Rezoning Transportation Analysis

Petition Number: 2022-203

Date	Description
4-27-23	First Review (PDM)

RZ1.0

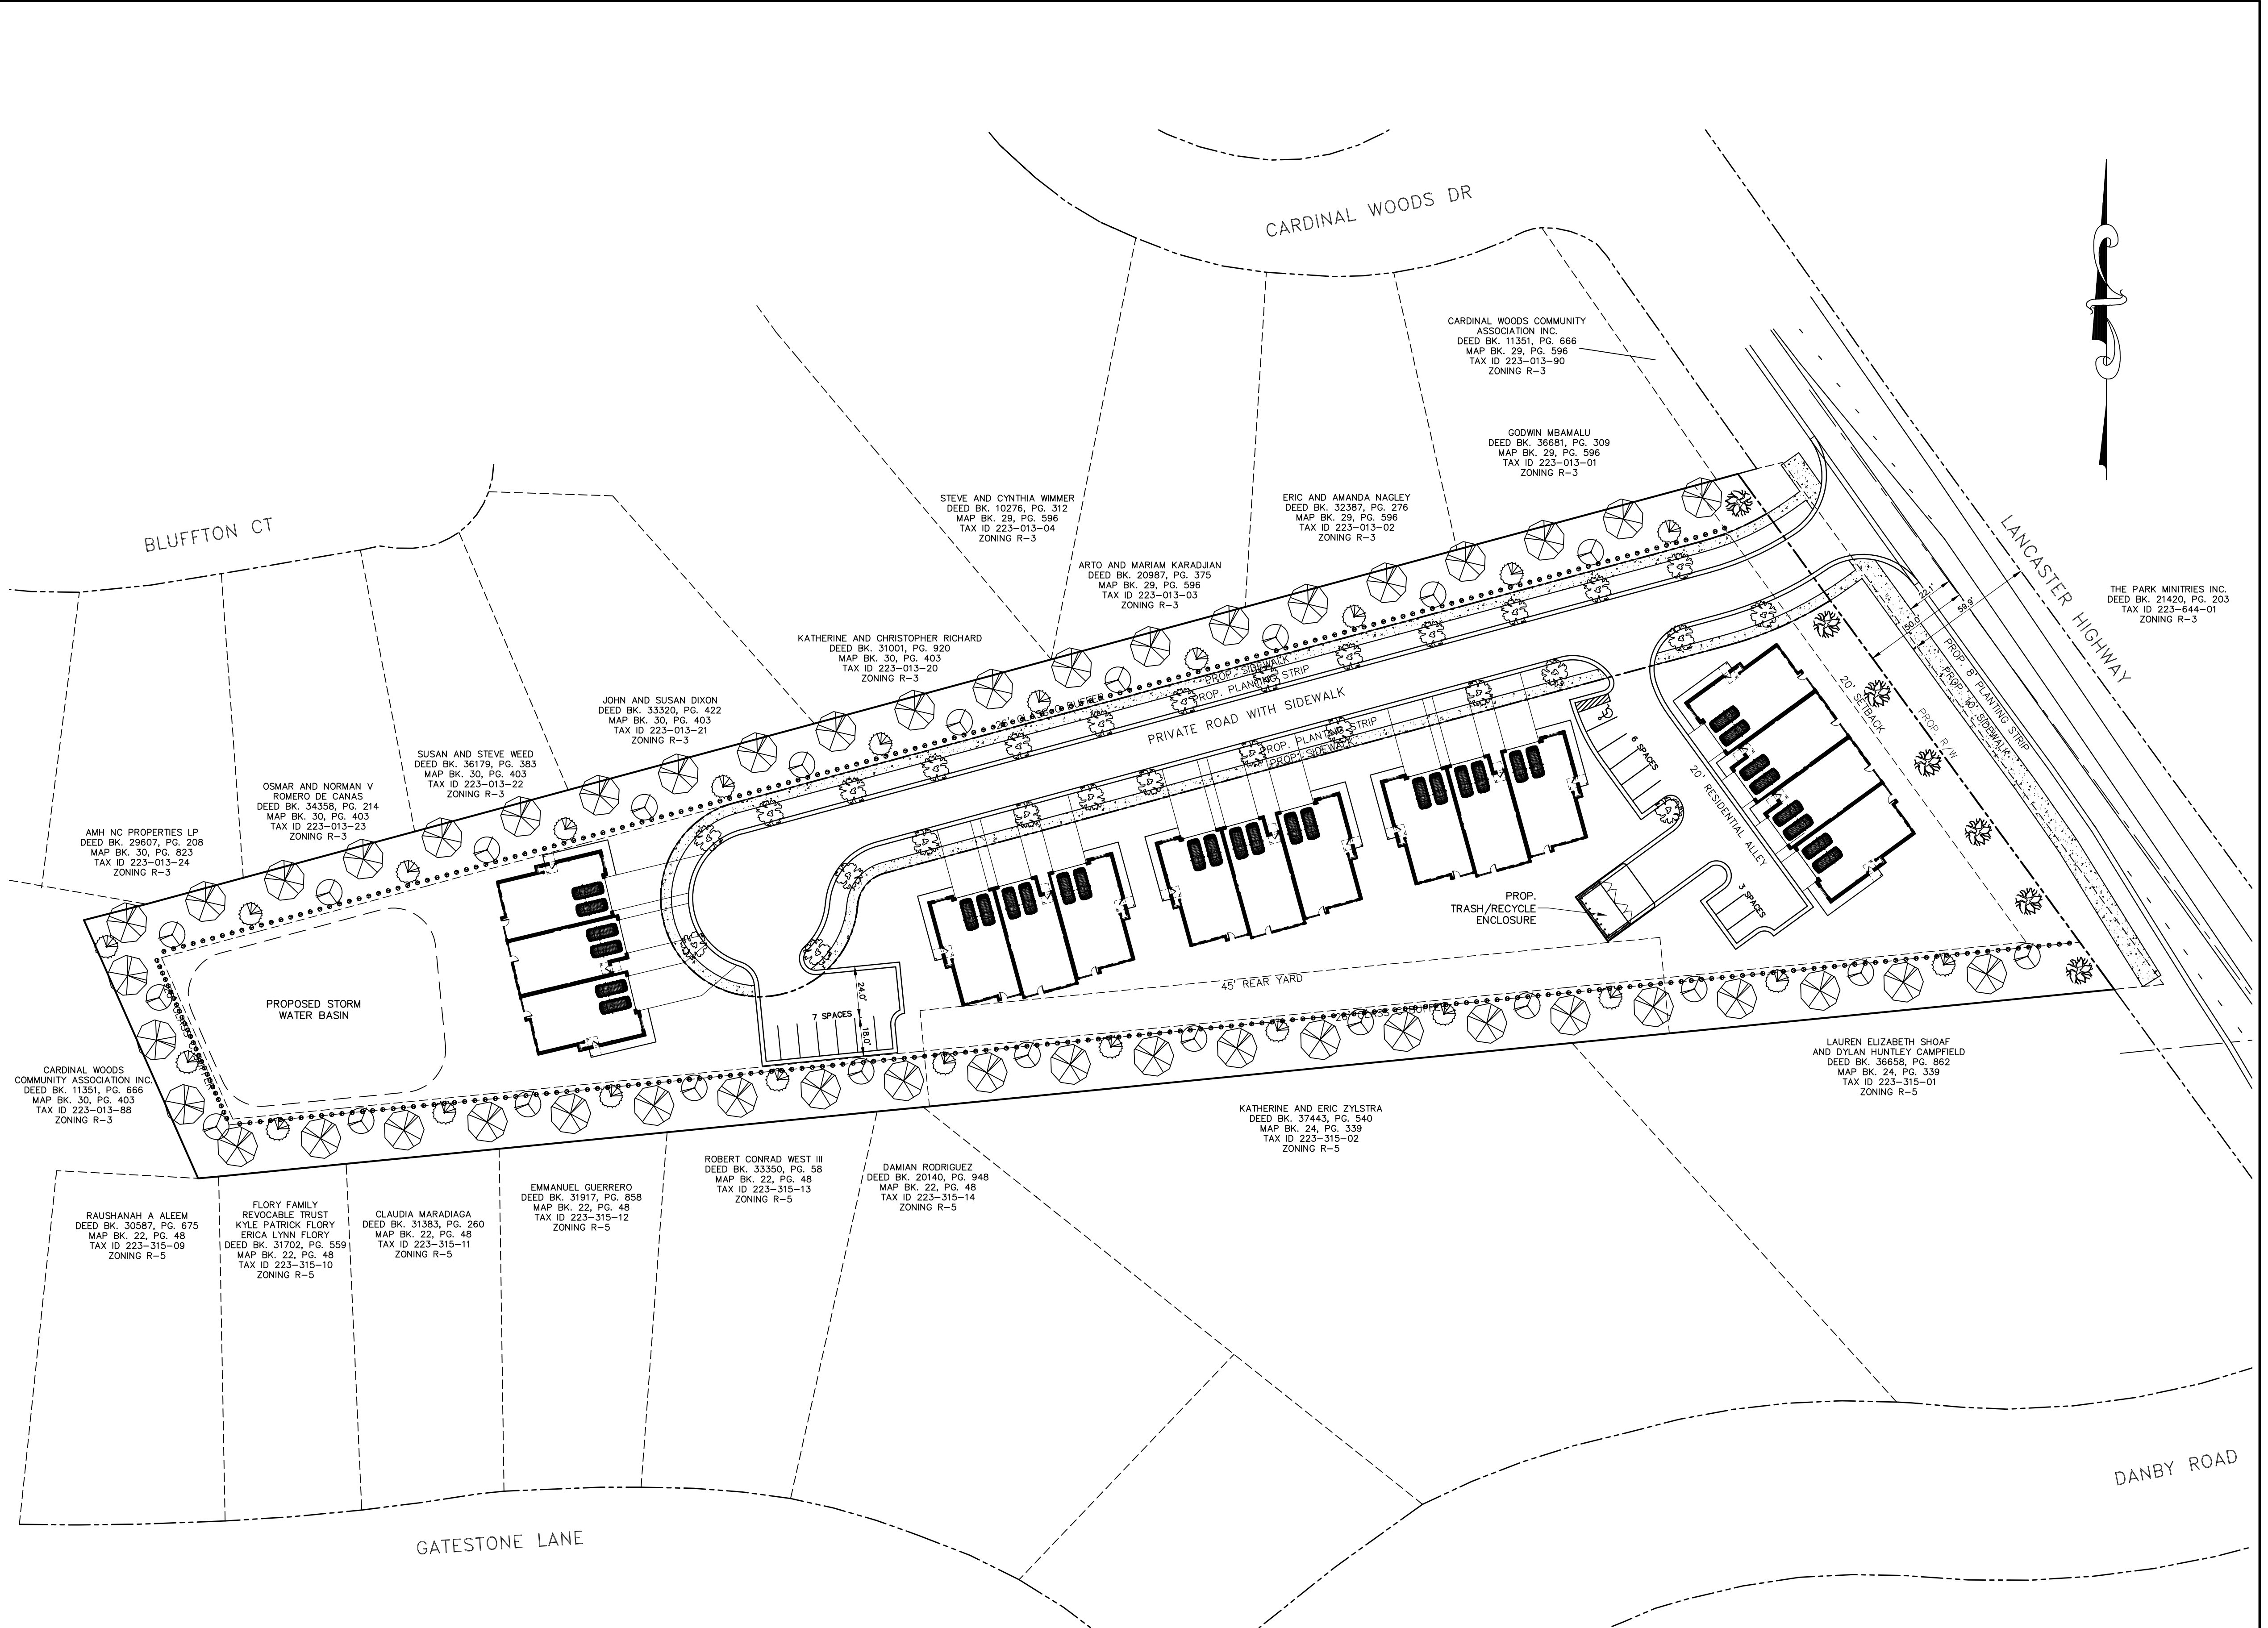
- Lancaster Highway:** Location of future curb and gutter to be installed to 30 feet from roadway centerline to accommodate the Charlotte Streets Map with a roadway typical section of four plus avenue with shared use path.

Label and dimension the future curb and gutter from the centerline for each road on the site plan.

- Per coordination with NCDOT, provide a left turn lane on Lancaster Highway at the proposed site access. A minimum of 50ft of storage should be provided.
- Revise site plan and conditional note(s) to commit to construct bicycle facilities by installing a 12' multi-use path to meet the Council-adopted Charlotte BIKES Policy. The MUP shall be located outside of the ROW.

7. Revise site plan and conditional note(s) to construct a 12-ft multi-use paths on Lancaster Highway outside of the right of way. The site plan shall label and dimension both items from the back of curb and gutter or edge of pavement. Add conditional note The entire facility must be outside of the right of way and within a public access easement. Add conditional note committing to construction and maintenance of the 12-foot sidewalks/multi-use paths on Lancaster Highway.
